Recommendation Report for Planning Permission for Works or Extension to a Dwelling

REF NO: BN/73/21/HH

LOCATION: 54 Highview Road
Eastergate
PO20 3XB

PROPOSAL: Garage conversion to habitable use and alterations to fenestration/openings

FOR MR & MRS BOOKER		
SITE 54 HIGHVIEW ROAD, EASTERGATE, WEST SUSSEX. P020 3XB		
TITLE PROPOSED ELEVATIONS		
SCALE 1:100	DRAWN AH 06/21	DRAWING NO. 05 REV

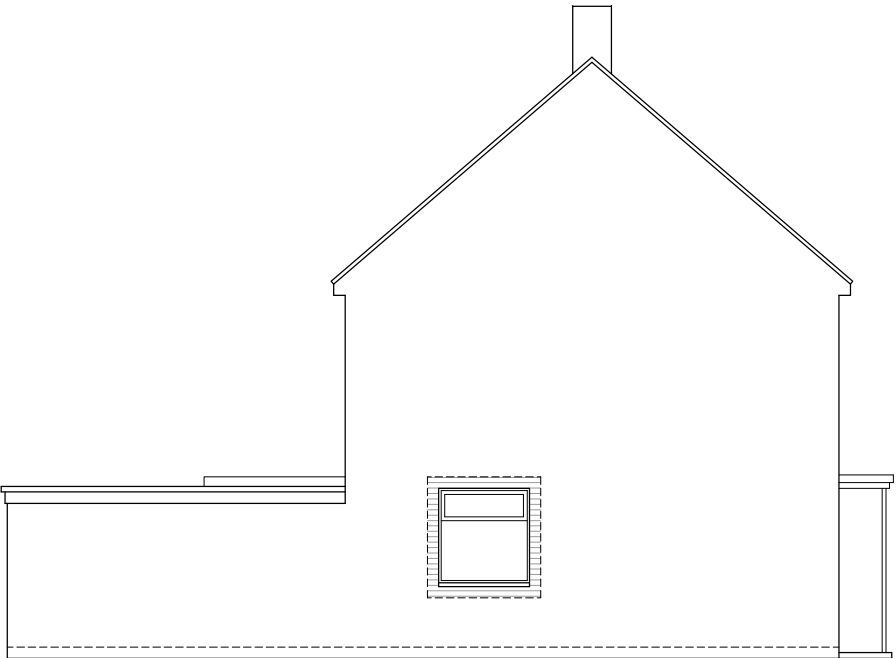
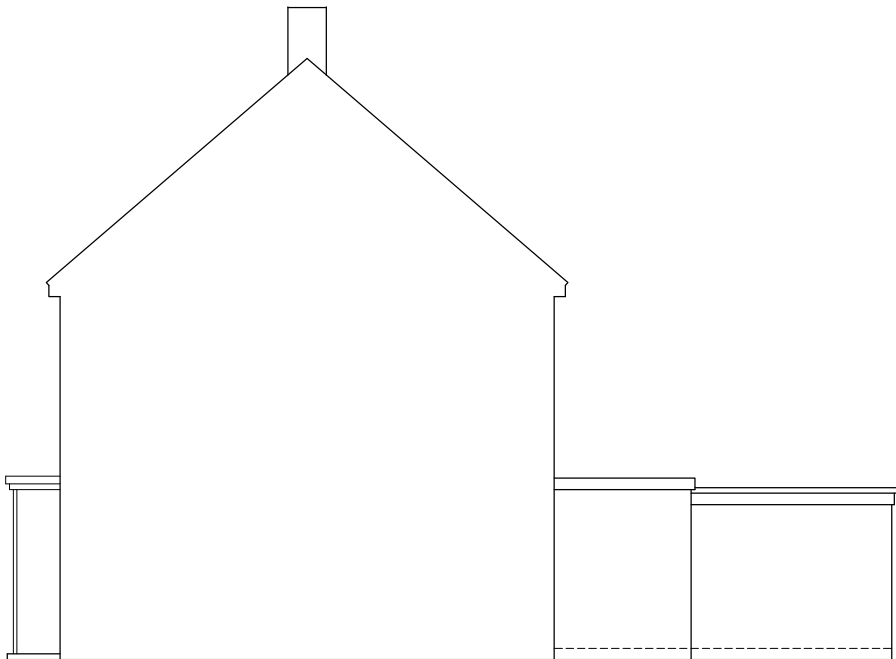
The proposals represent internal alterations to the layout of the dwelling. The only external alterations are the removal of a garage door and its replacement with brickwork and a single window. The proportions of the window match those at first floor and the appearance of the dwelling will not be adversely affected by the proposals. The proposed internal alterations and new window on the front elevation would be classed as permitted development.

FOR MR & MRS BOOKER		
SITE 54 HIGHVIEW ROAD, EASTERGATE, WEST SUSSEX. PO20 3XB		
TITLE PROPOSED GARAGE CONVERSION BLOCK PLAN		
SCALE 1:500 © A3	DRAWN AH 06/21	DRAWING NO. 01B REV.

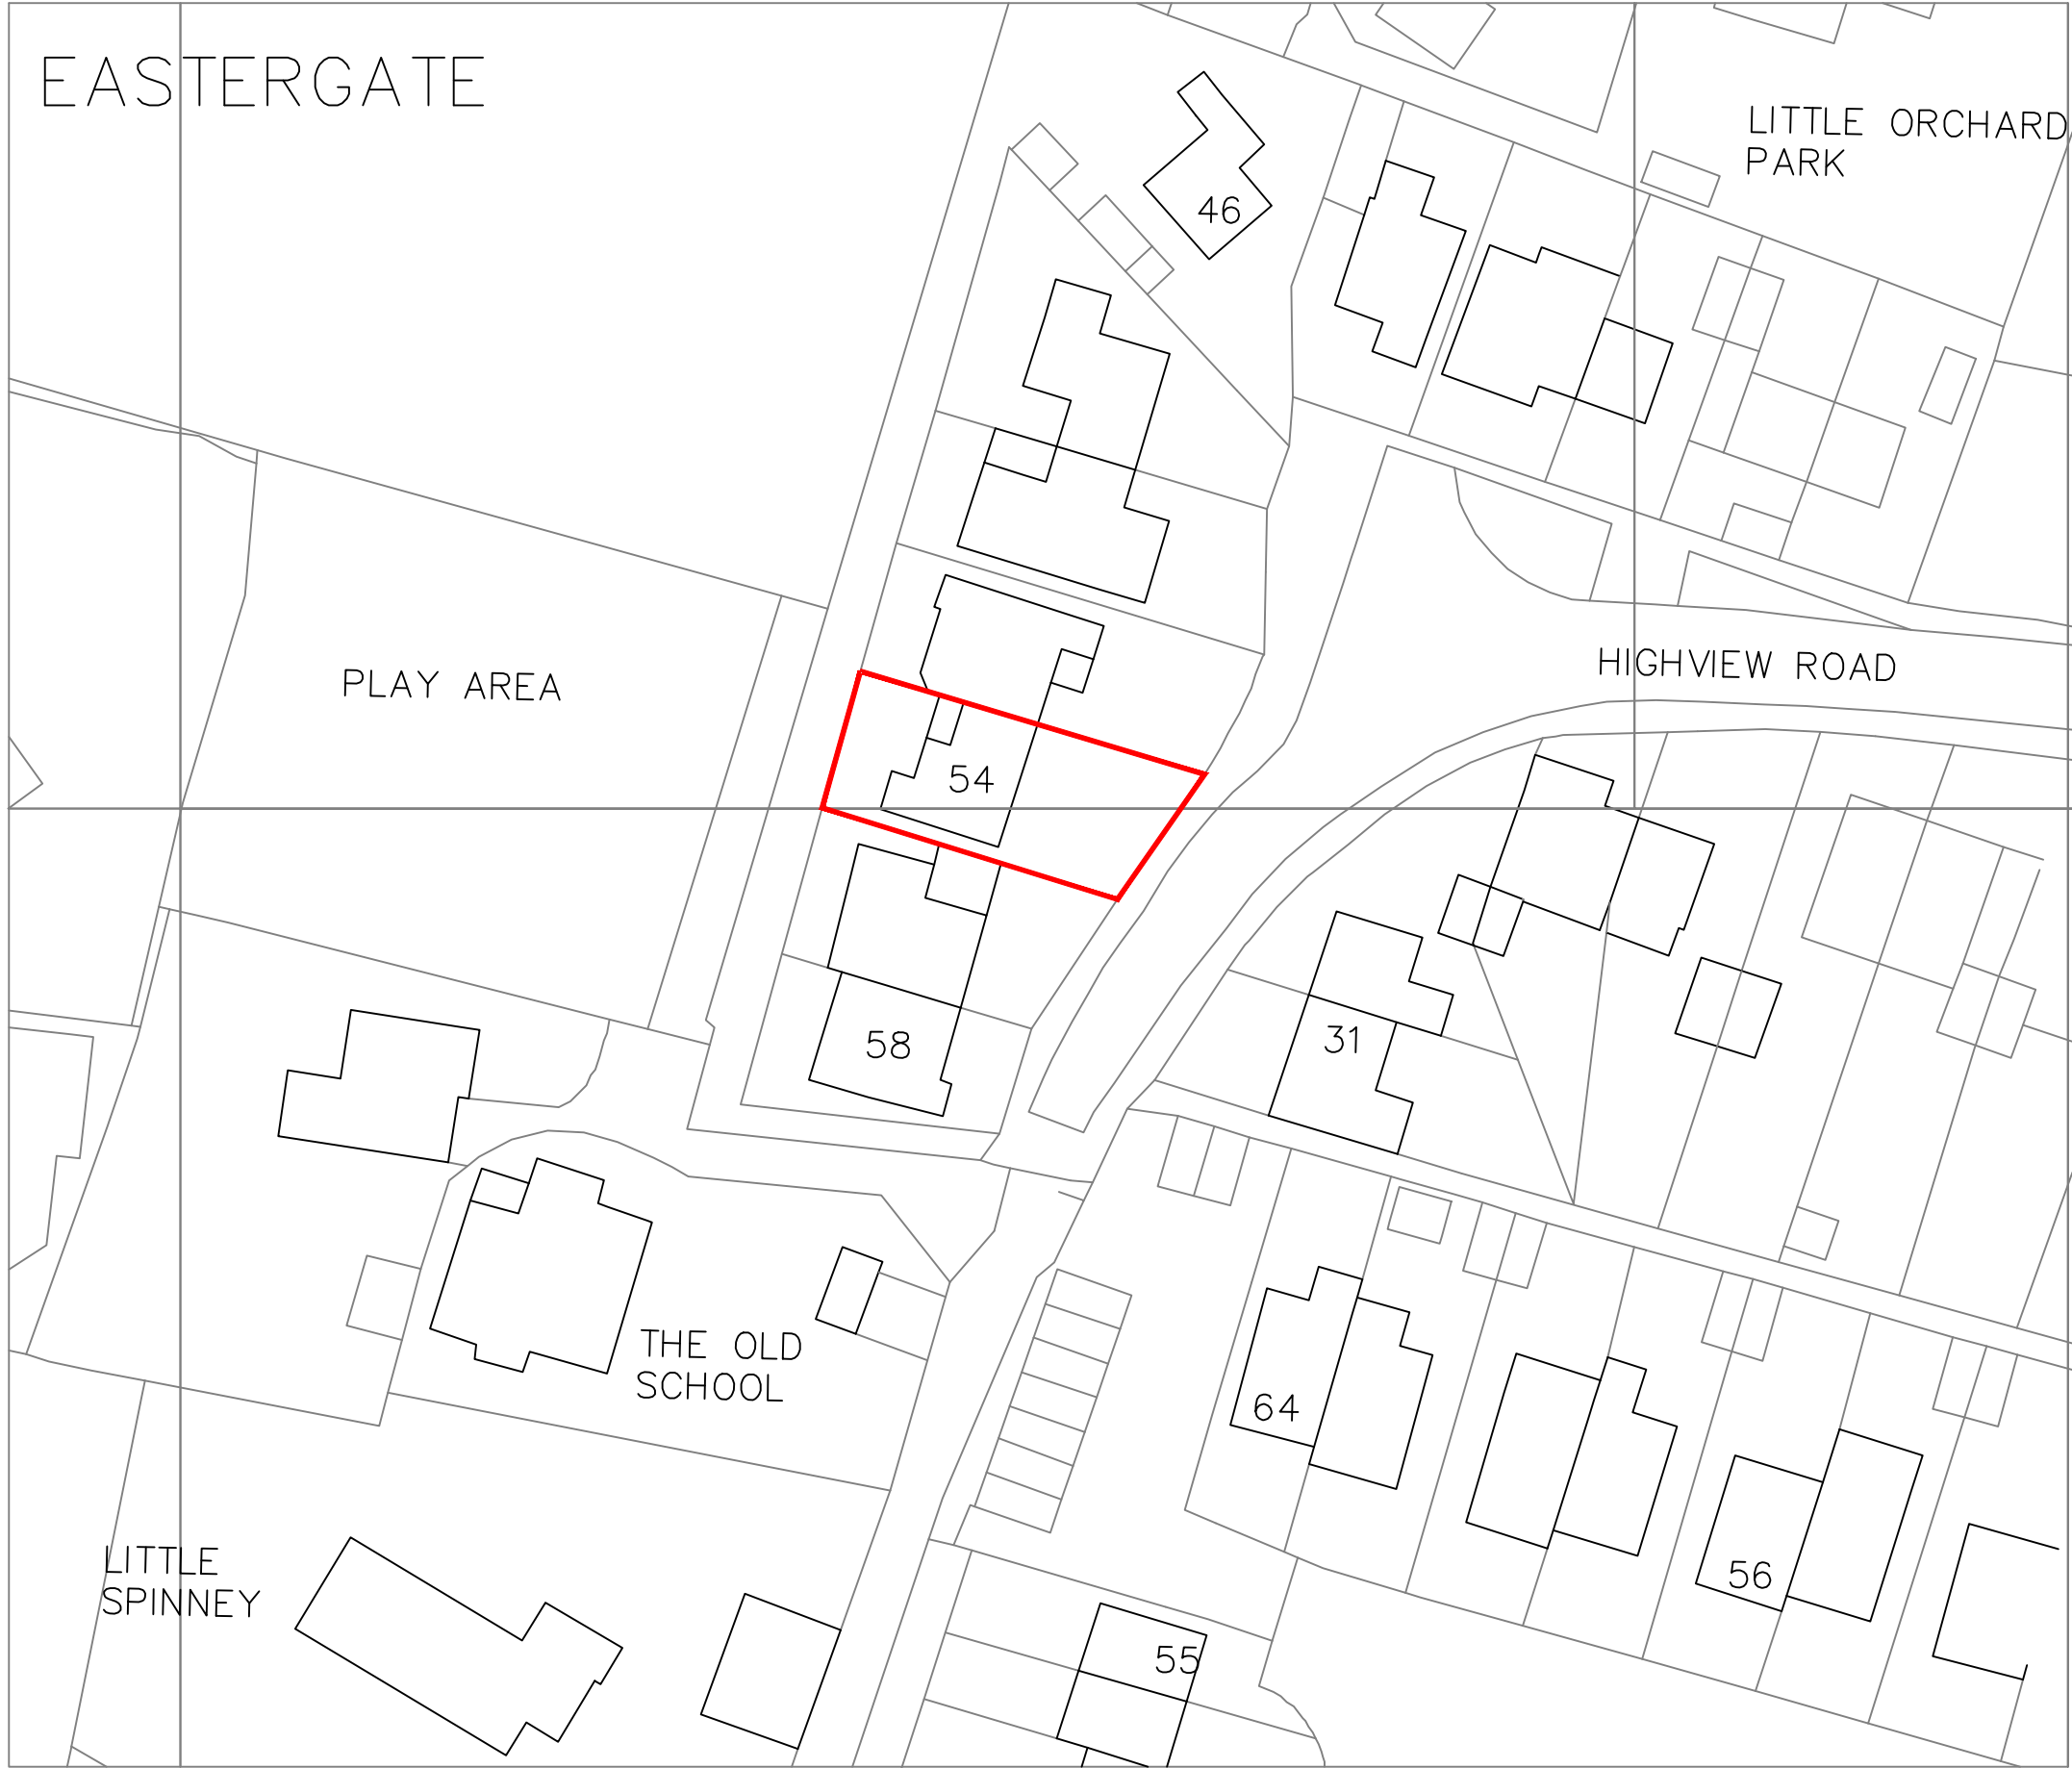
The proposal involves the loss of a garage but retains space for two vehicles to park off-street which would accord with the guidance in Arun's adopted Parking Standards. There is also ample on-street parking available.
